THE HILLS SHIRE COUNCIL

15 March 2018

Council received notification on 5 February 2018 of a Section 75W application made to the NSW Department of Planning and Environment to modify a Part 3A approval for a seniors living development at 34-36 Memorial Avenue, Kellyville.

Cluster 1

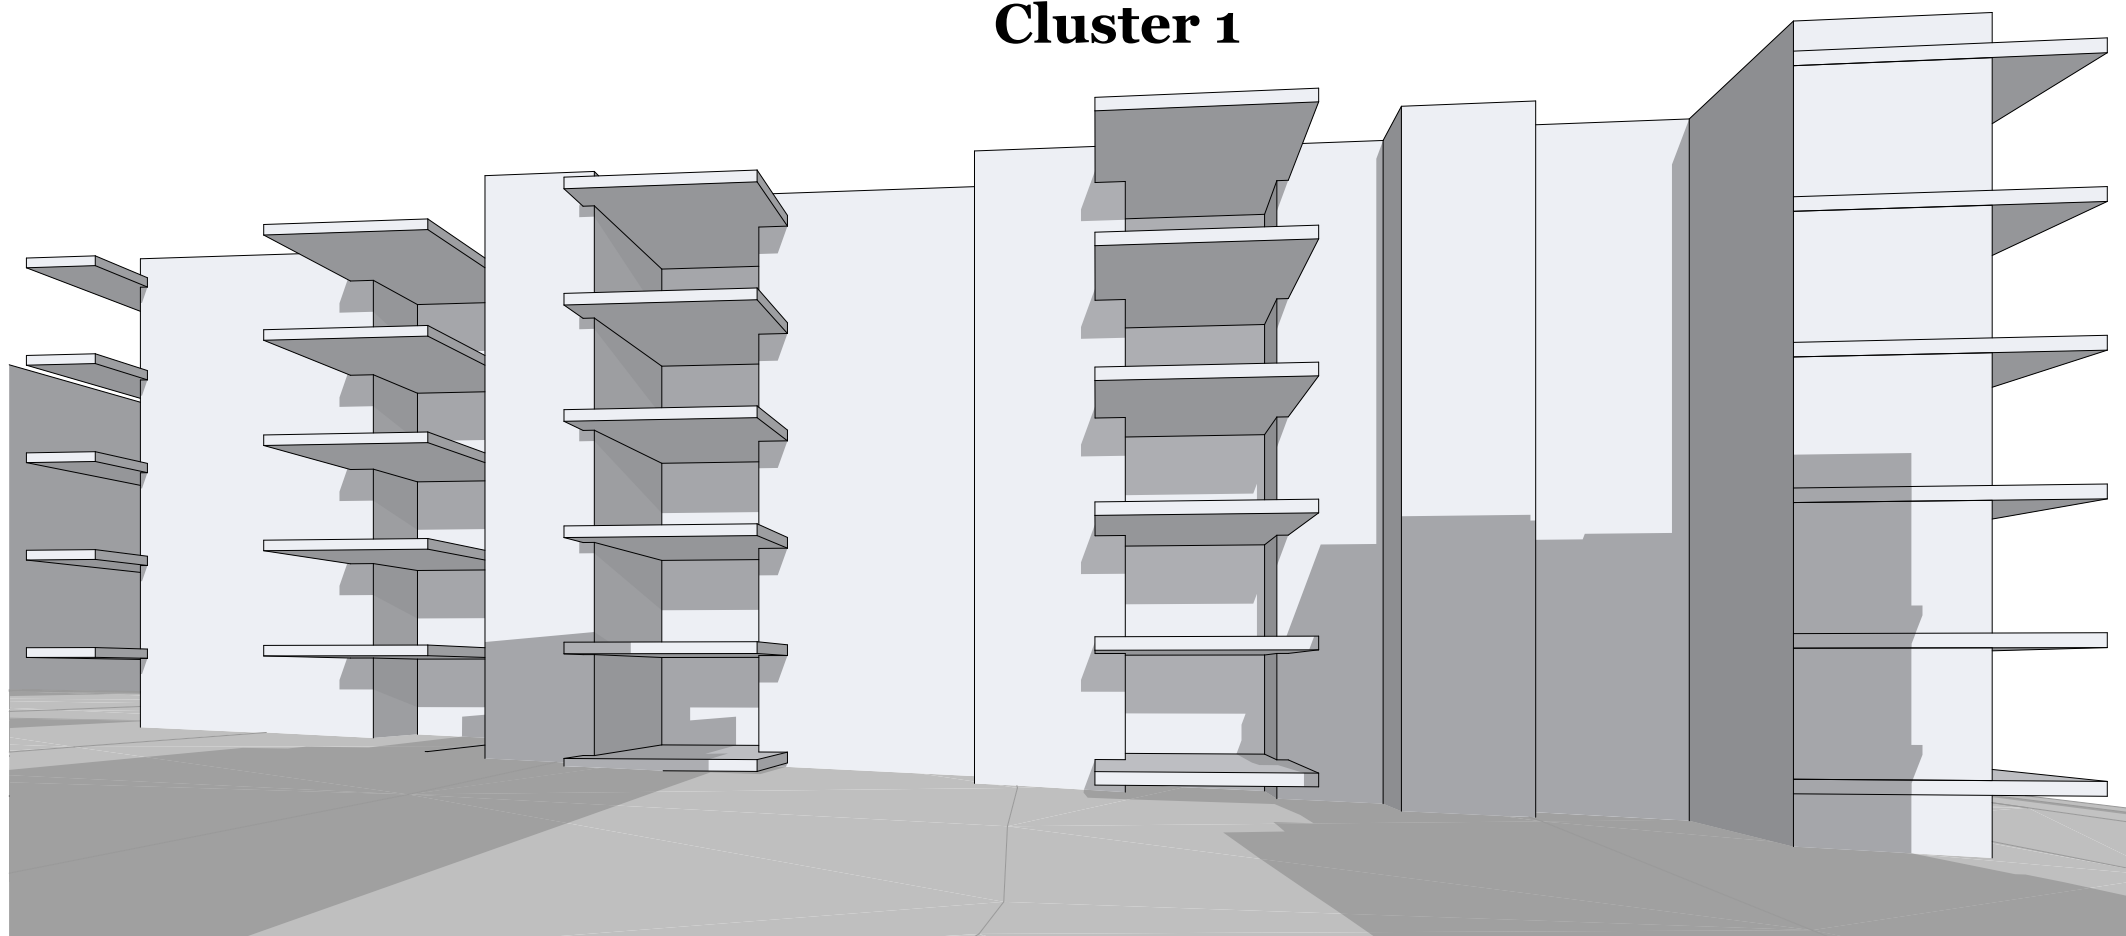
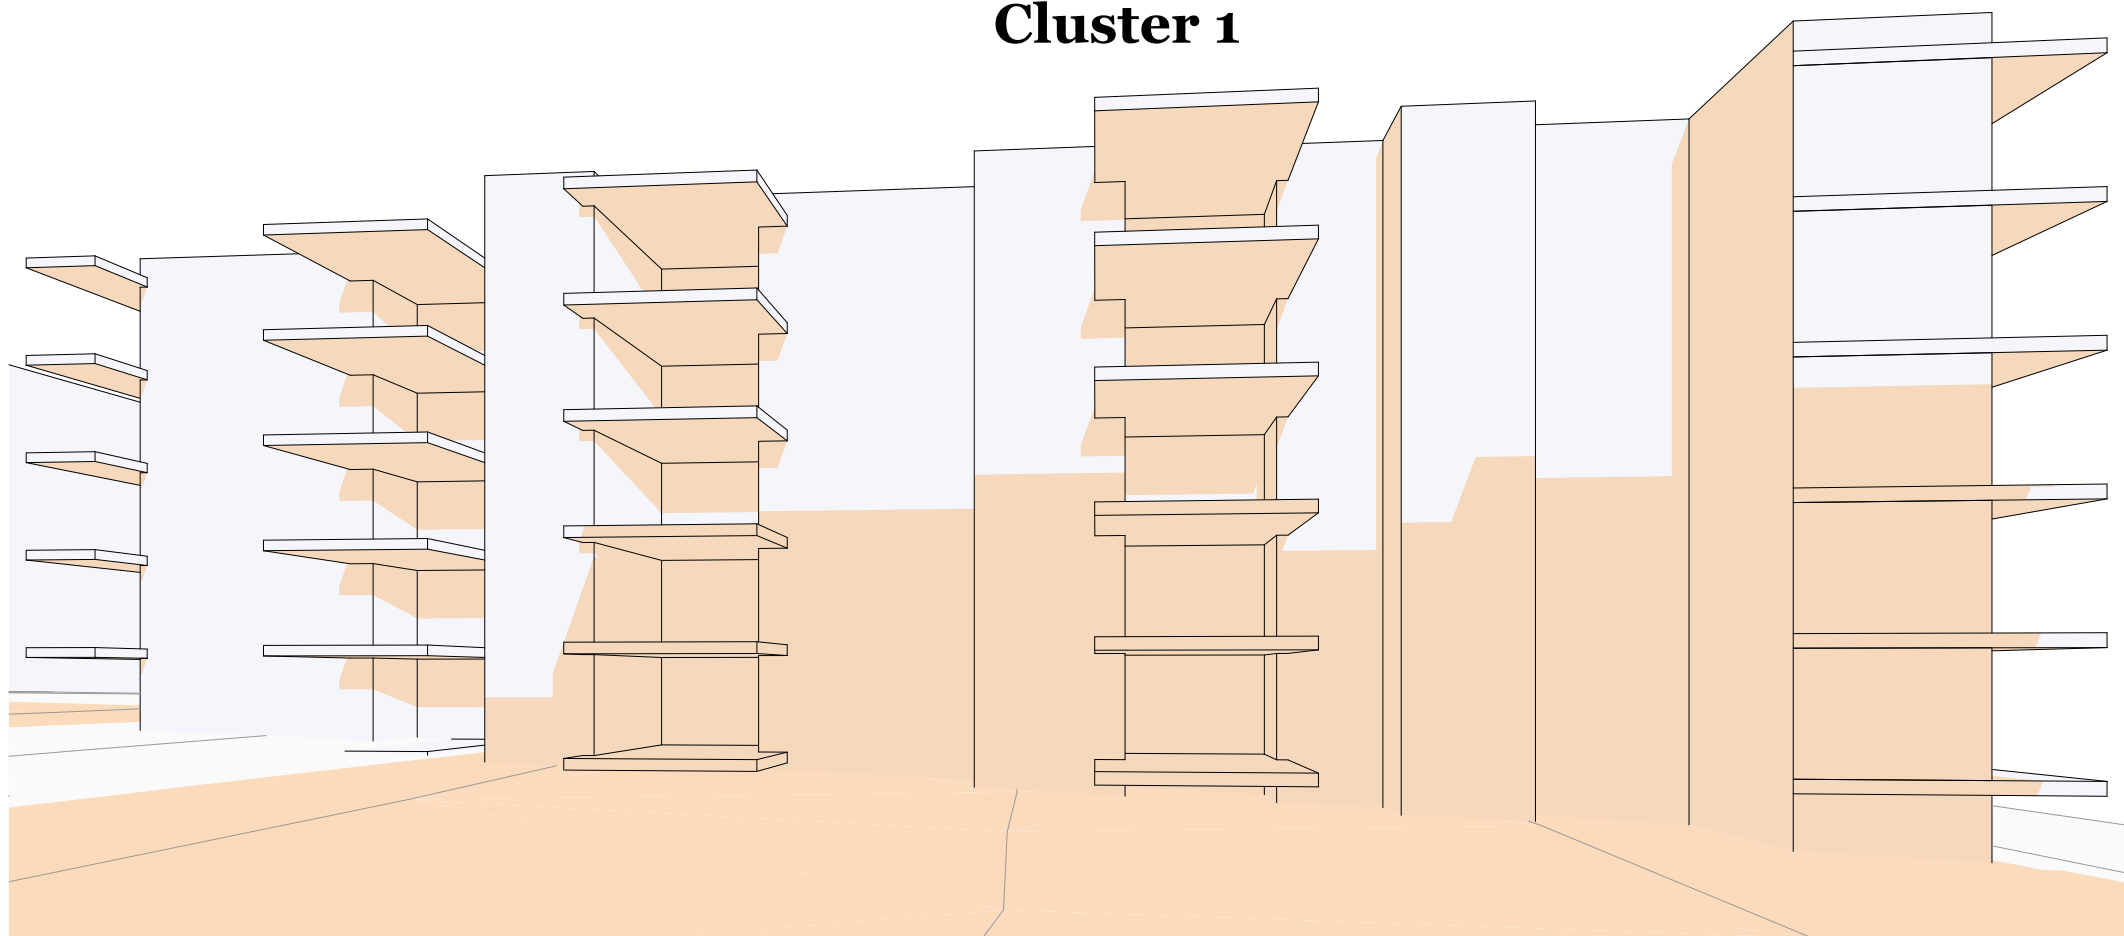
- The proposal has not provided a clear assessment of the proposals impact on the solar access afforded to adjoining buildings known as Cluster 5, or the RACF impact on the solar access afforded to the proposed buildings. Analysis similar to that provided for Cluster 1 should be provided to the northern elevation of Cluster 2, 3 and 4 (to assess the impact of the RACF), and the northern elevation of Cluster 5.

TYPICAL PUMP-OUT PIT SECTION - DRIVEWAY DRAINAGE
SCALE 1:20

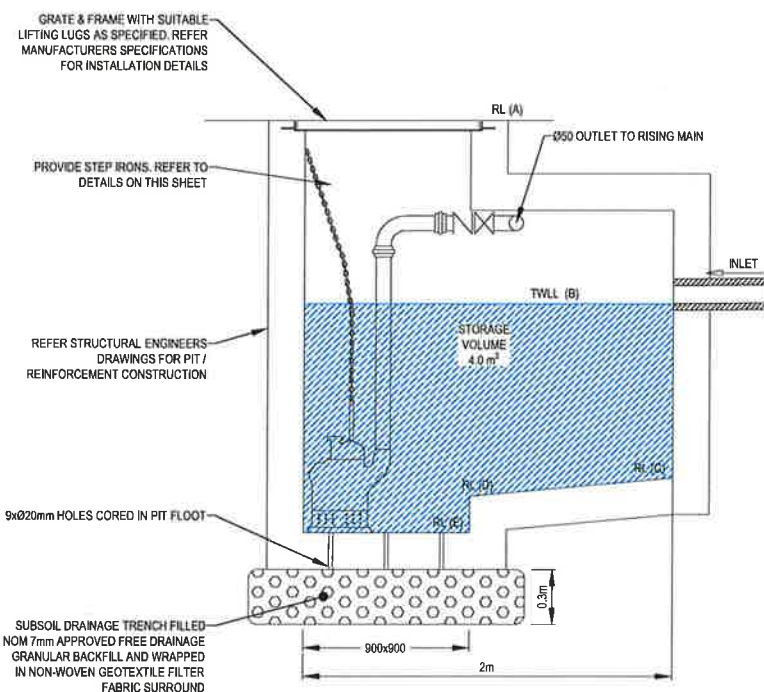
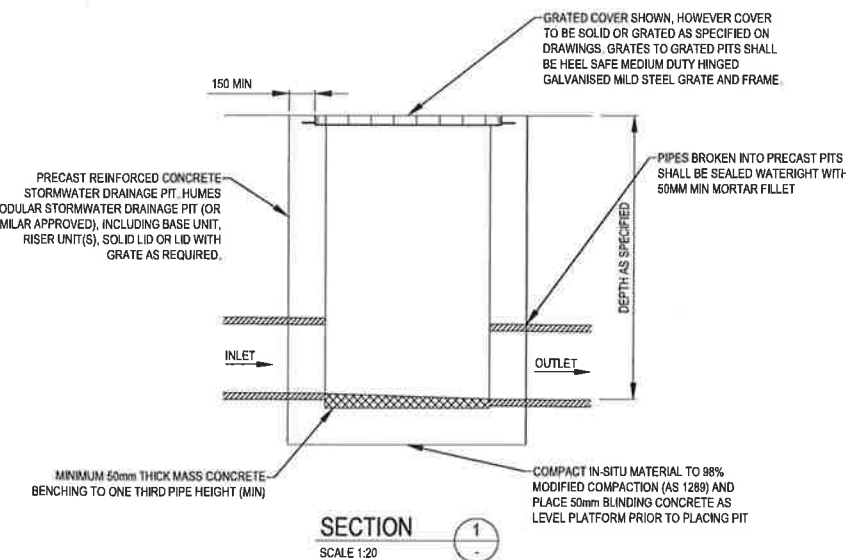
- A condition is required stating that the basement access is protected from flooding as outlined in the stormwater report.
- A condition is required stating that all runoff is directed to the existing sag in Free Settlers Drive rather than being sent north towards Memorial Avenue (as the RMS design for that road has not been sized to cater for any runoff from these development sites and is the subject of current discussions between the RMS, BECA and Council staff).
